Please ask for: Sian Eggington
Email: sian.eggington@terraquest.co.uk
Telephone: 0121 2341390
Our Ref: AB/45/20/HH
Your Ref:
Date: 26th May 2020

Application for Planning Permission for Works or Extension to a Dwelling

Development: Roof alteration from hipped roof to front and rear gable in order to create additional rooms in the roof. Erection of decking in the rear garden.

Location: 19 Priory Road Arundel BN18 9EJ

## BLOCK PLAN

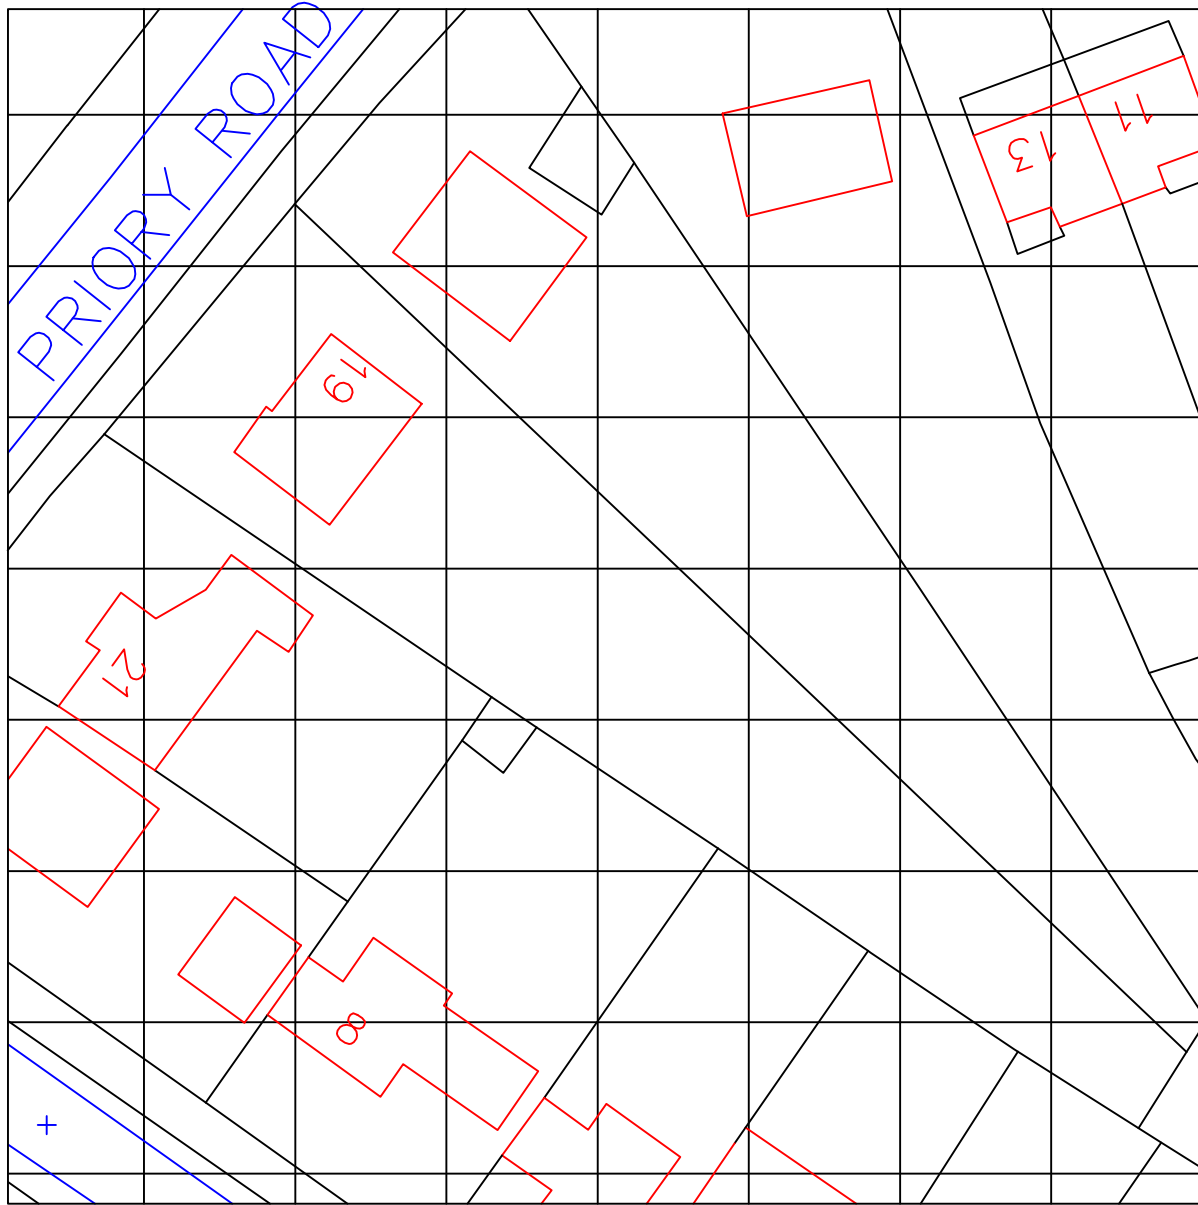
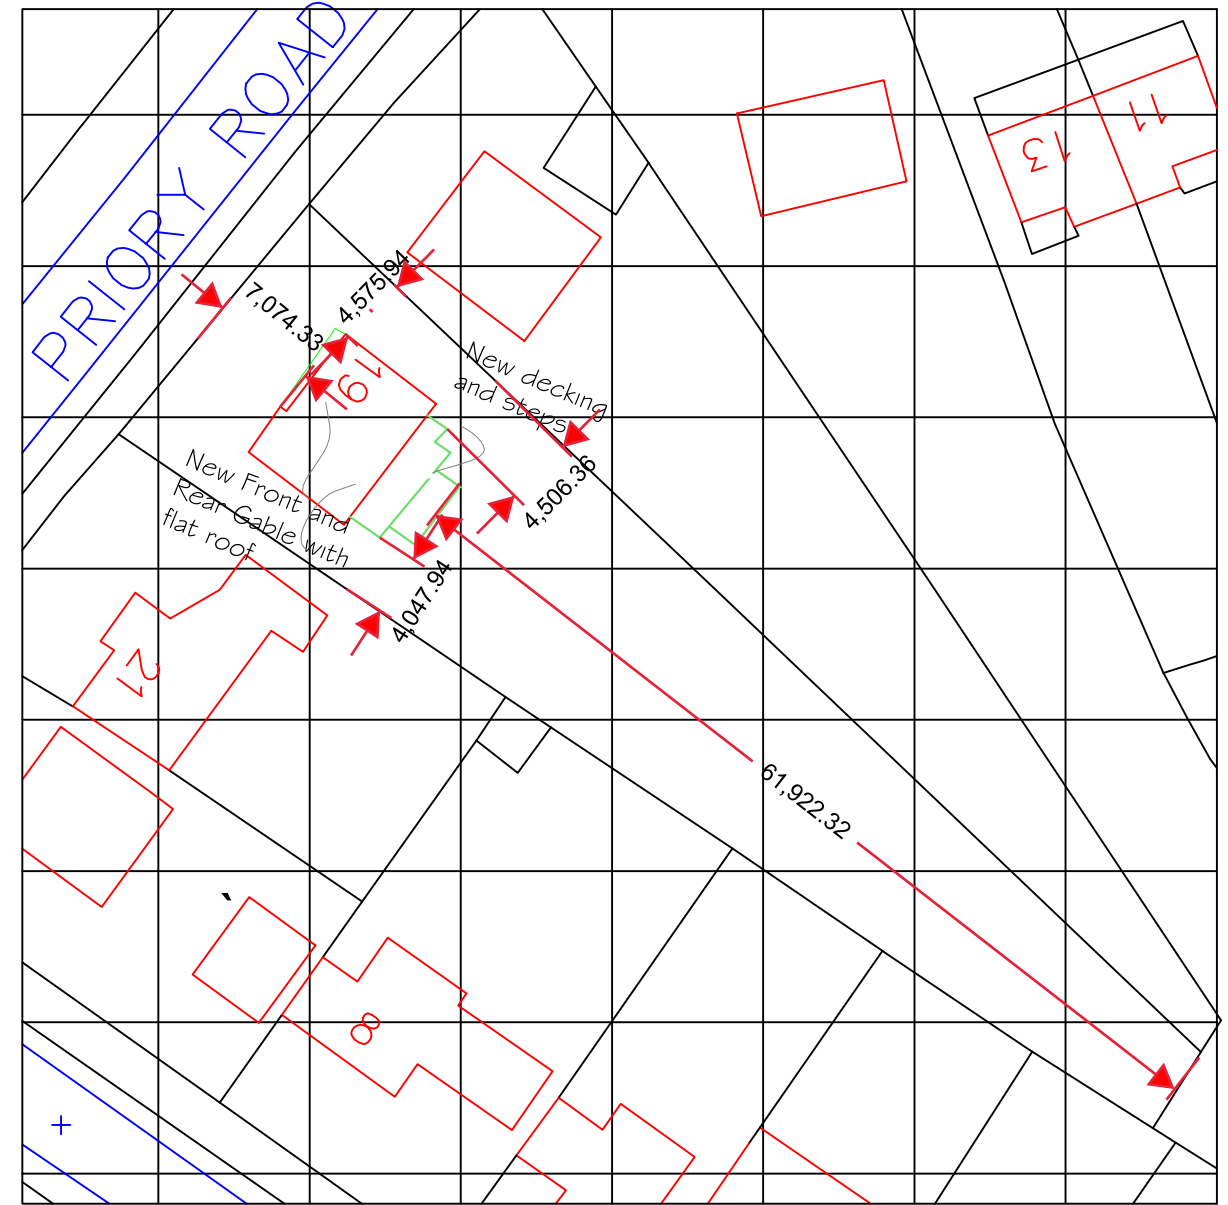
Block Plan: You are required to include dimensions from the proposed extension to all site boundaries. Please amend.
